Please find the following summary of changes that have been updated on our drawings for the Residential Building R5 RTS SSD6966 following your email on the 29 April 2019. These drawings are numbered as follows

- RPB430-GE-R5000-GA Revision R – General Arrangement
- RPB430-GE-R5001-GRND Revision O – Ground Floor
- RPB430-GE-R5002-PO2 Revision N - Podium Level 02
- RPB430-GE-R5003-L26 Revision N – Level 26
- RPB430-SE-R5004 Revision H – Podium Level 02
- RPB430-SE-R5005 Revision A – Section Public Domain
- RPB430-SE-R5006 Revision A – Waterman's Quay
- RPB430-SE-R5007 Revision A – Hickson Road

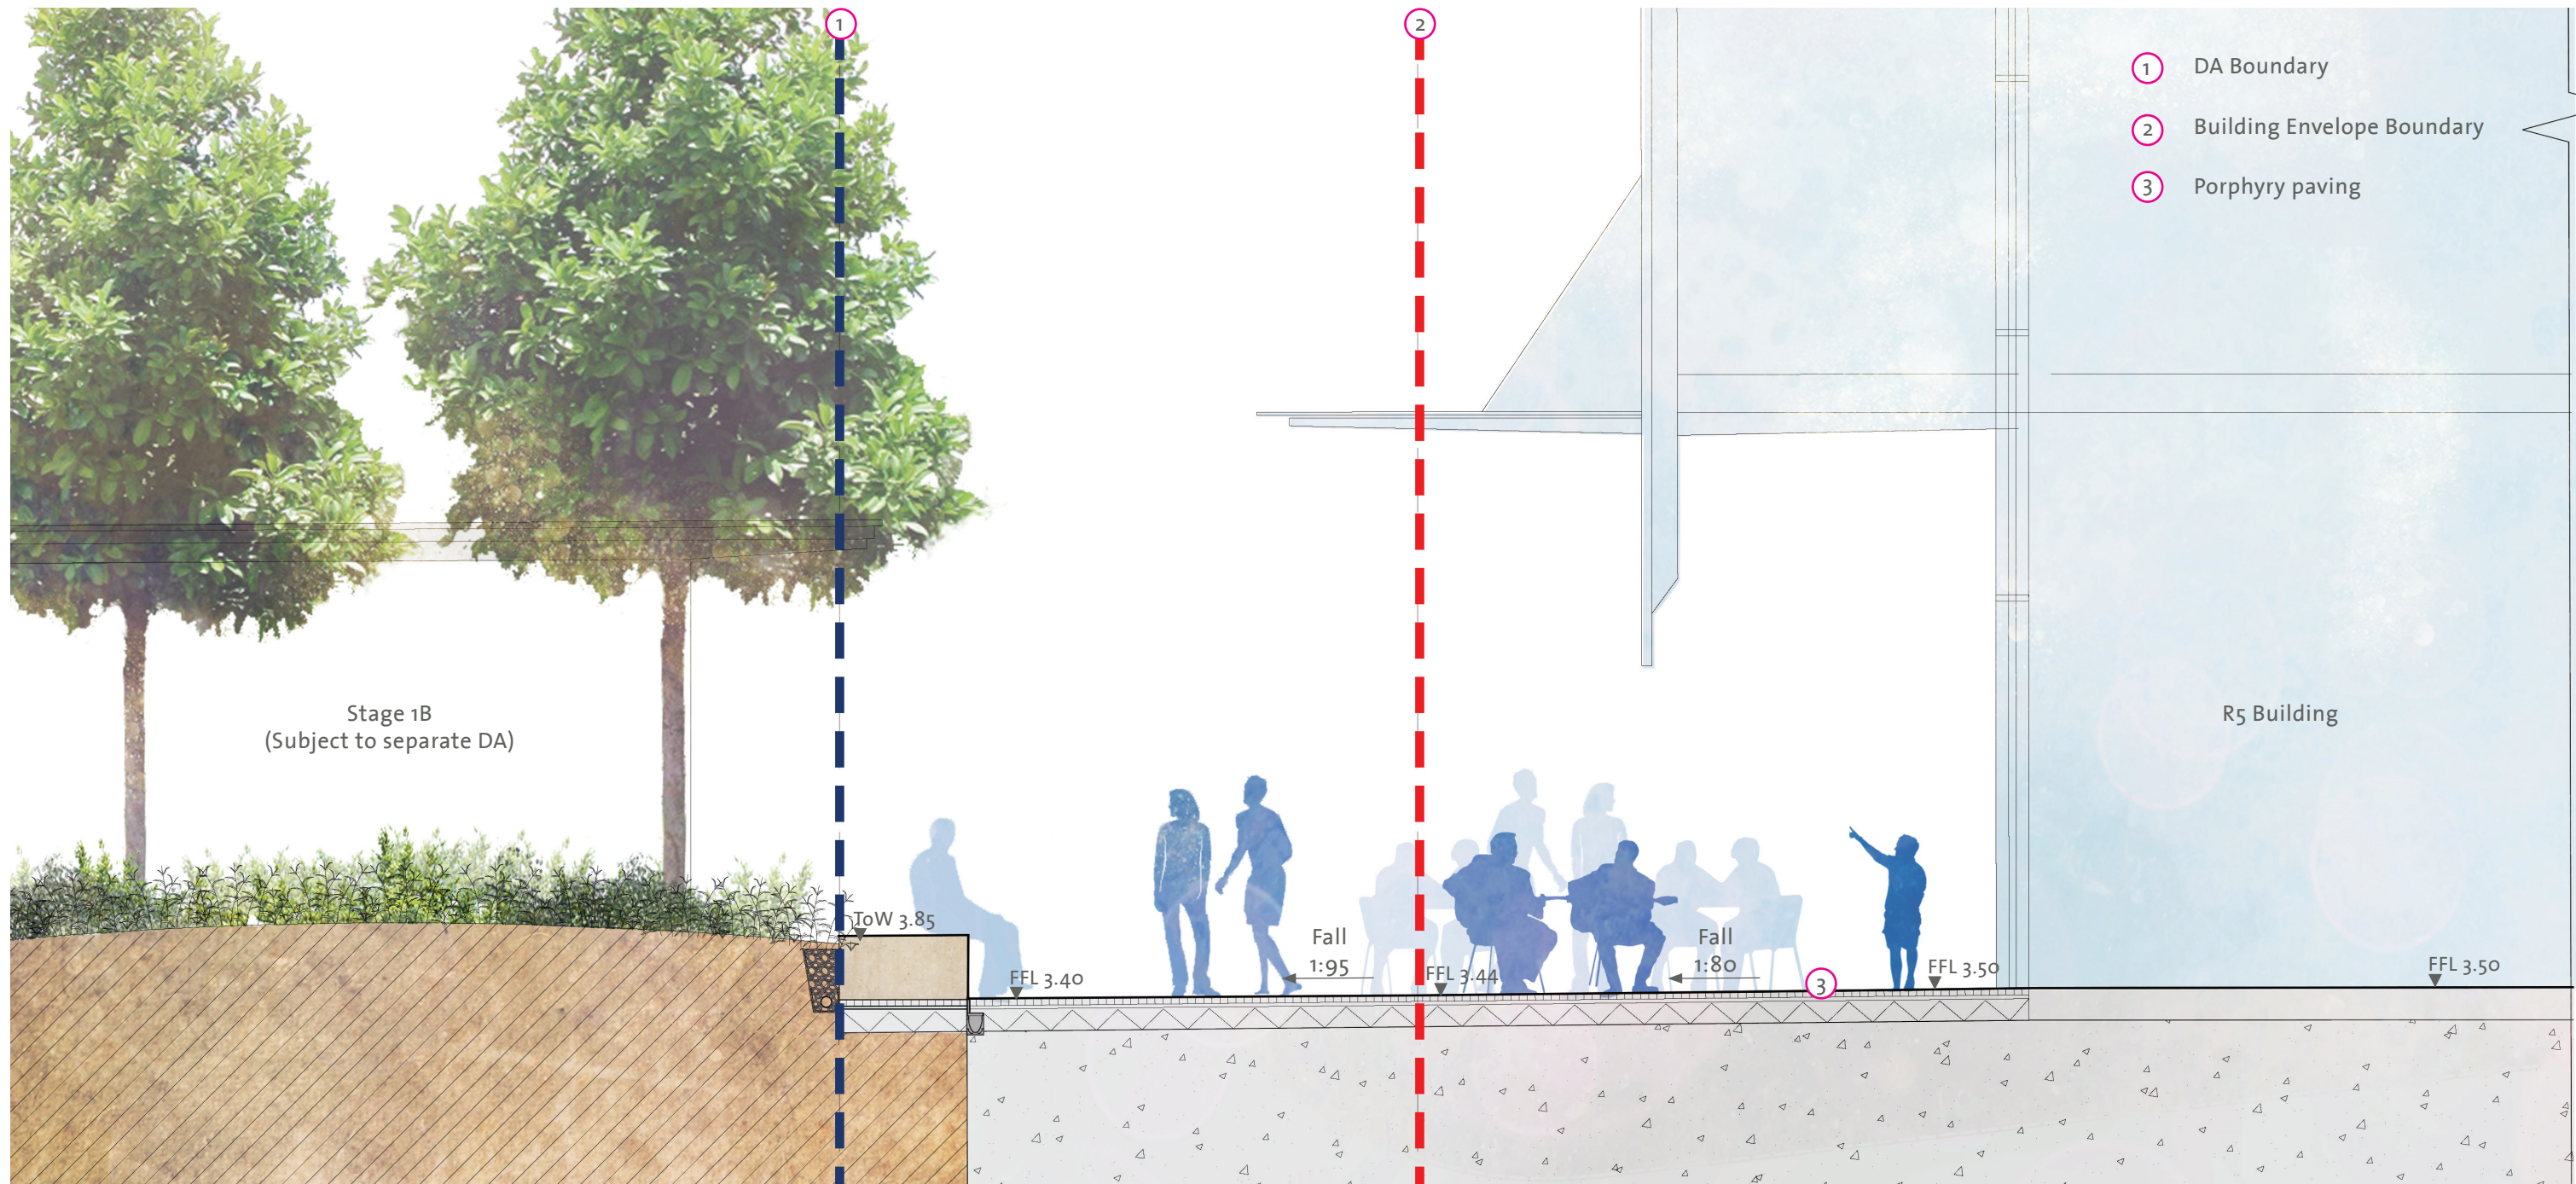
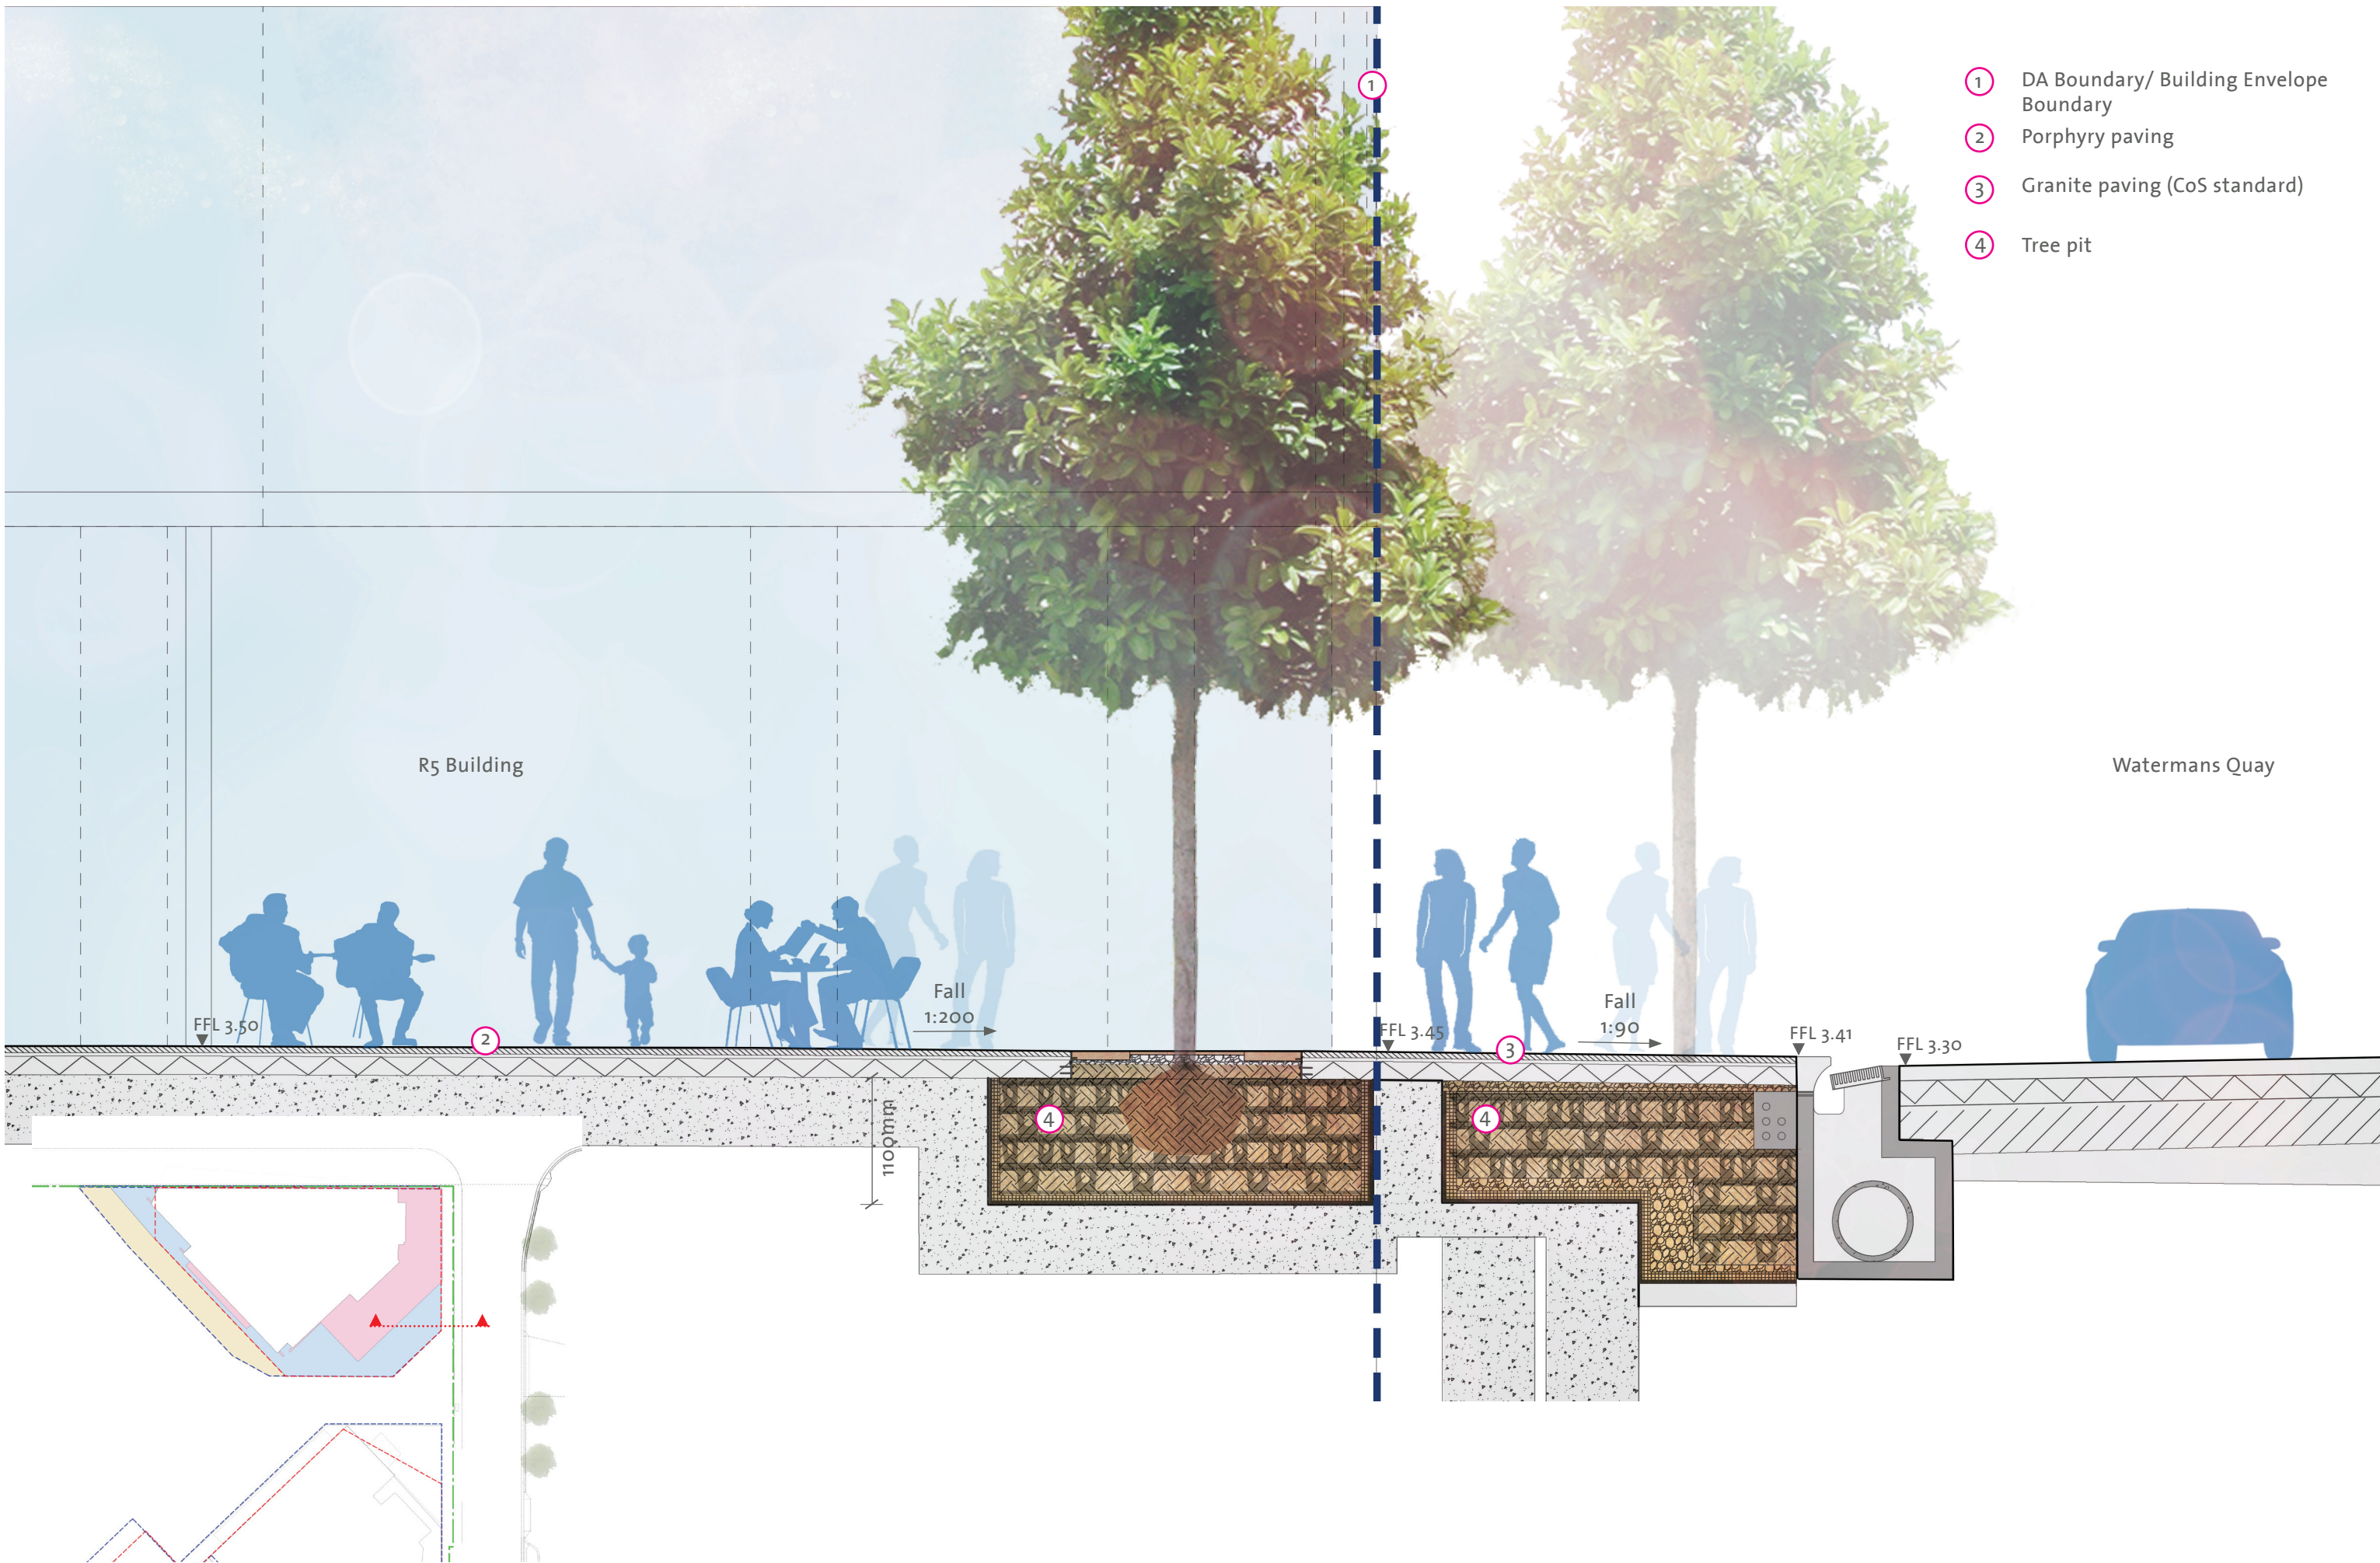
Provide further details on the design of the common spaces, and confirm adequate conditions can be provided for tree growth and safety balustrades can be accommodated to meet BCA requirements.

The tree pits will be provided with adequate volume (typically 16-18m³ per tree) and depth (minimum of 1000mm) for growing media. They will include appropriate drainage, aeration and irrigation. The balustrade has been added to drawing RPB430-SE-R5004 Revision H – Podium Level 02. This will be detailed by the Architects in accordance with code/BCA regulations.
